Online Comment

Application H02-0598-25
Location Land South of Barn Lodge Commercial Premises Hereward Way
Proposal Proposed Residential Development Comprising 3 Detached Dwellings

Name Parish Clerk
Address Crowland Parish Council

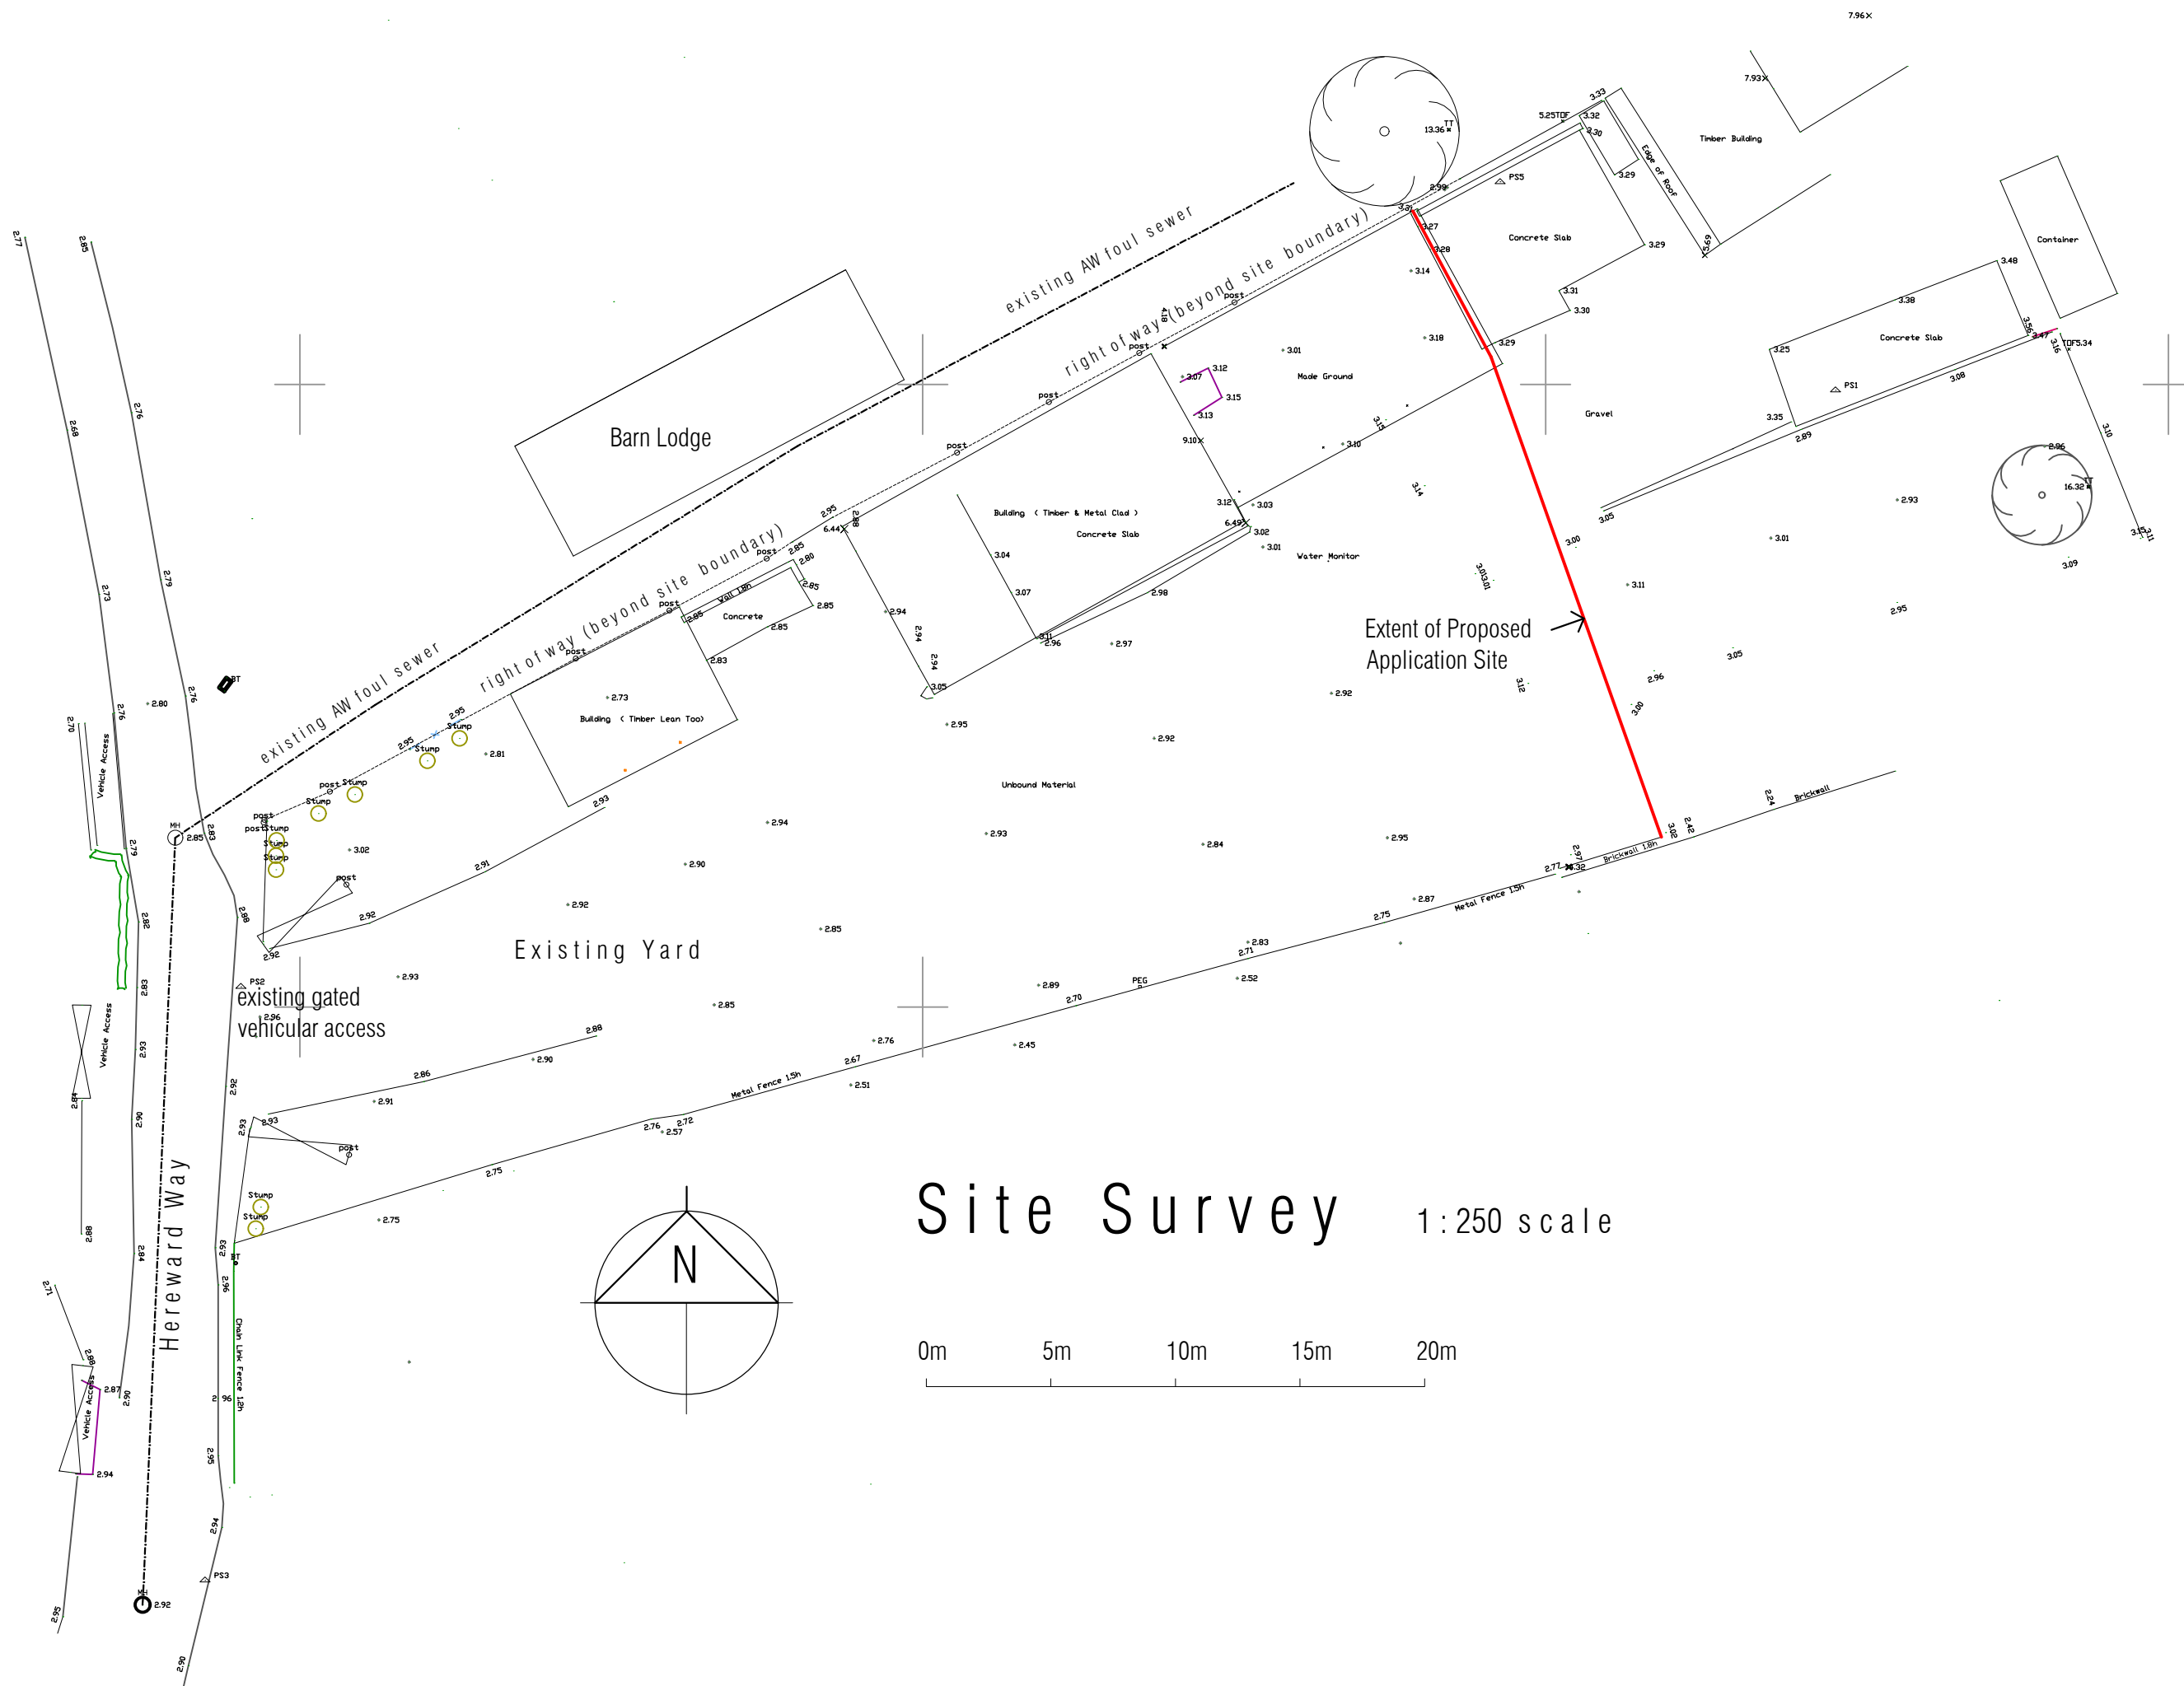
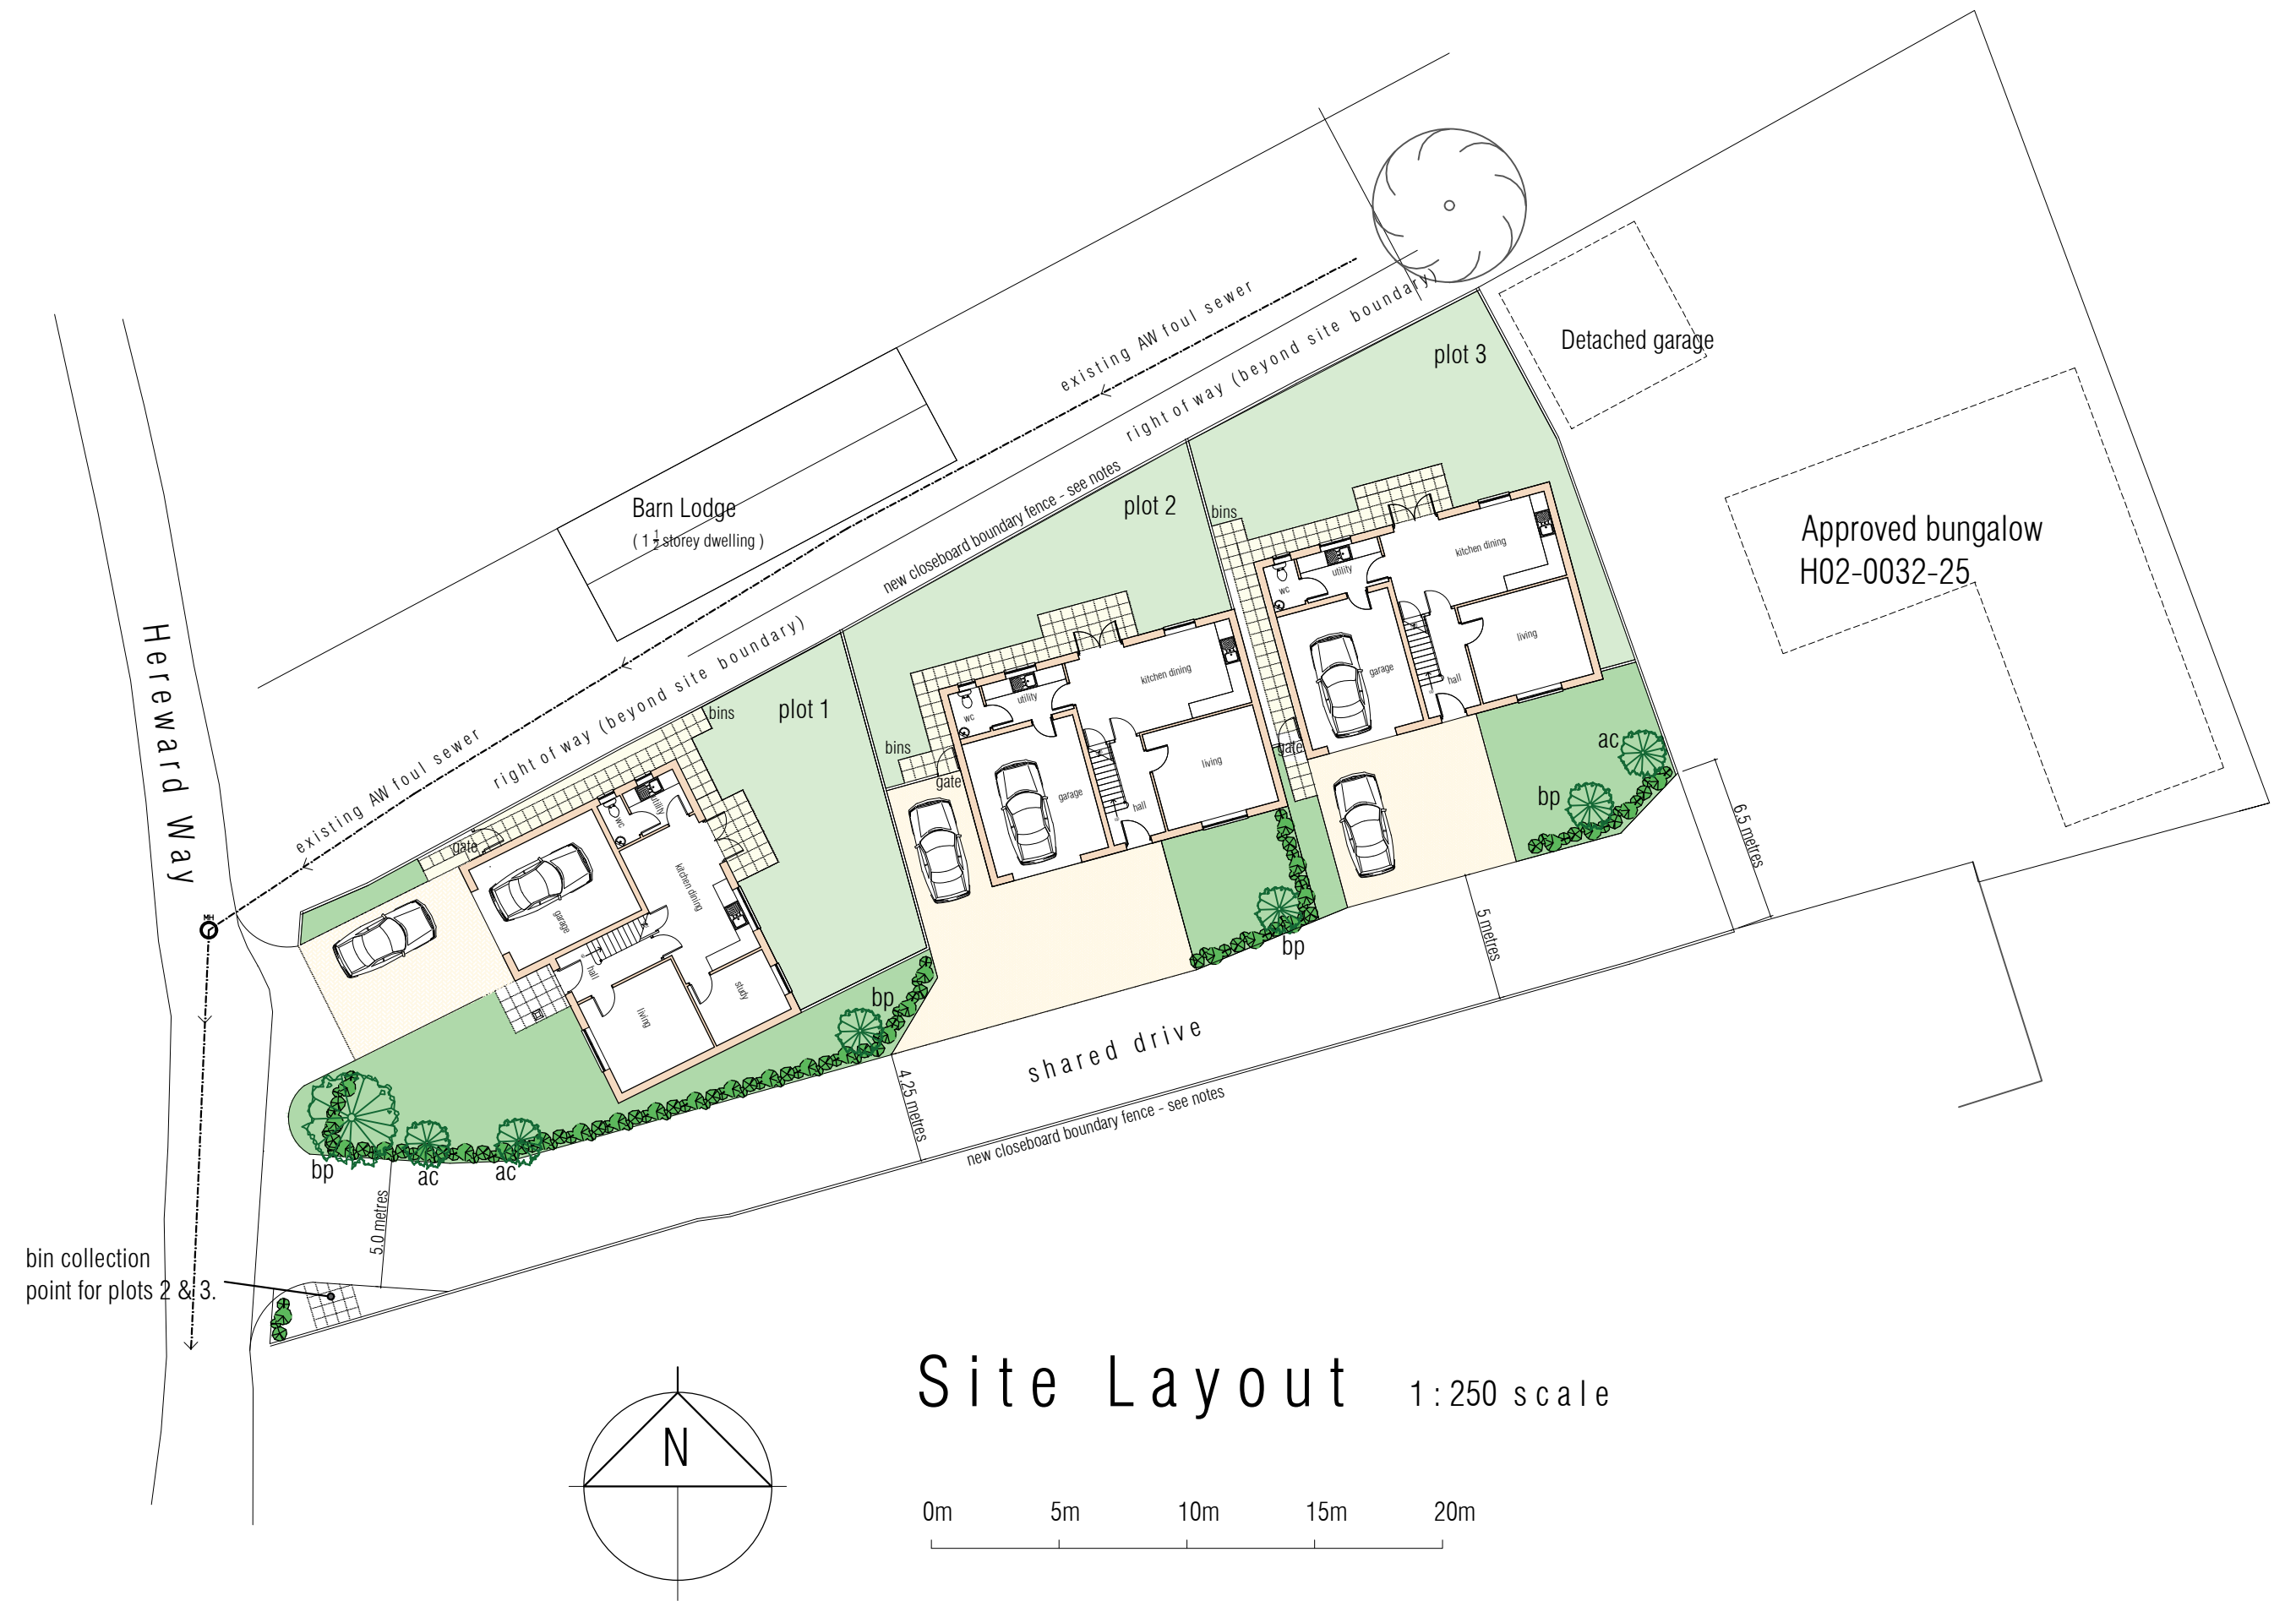
CPC comment issues with the general state of the road, no footpath provision and the road narrows at the access point.
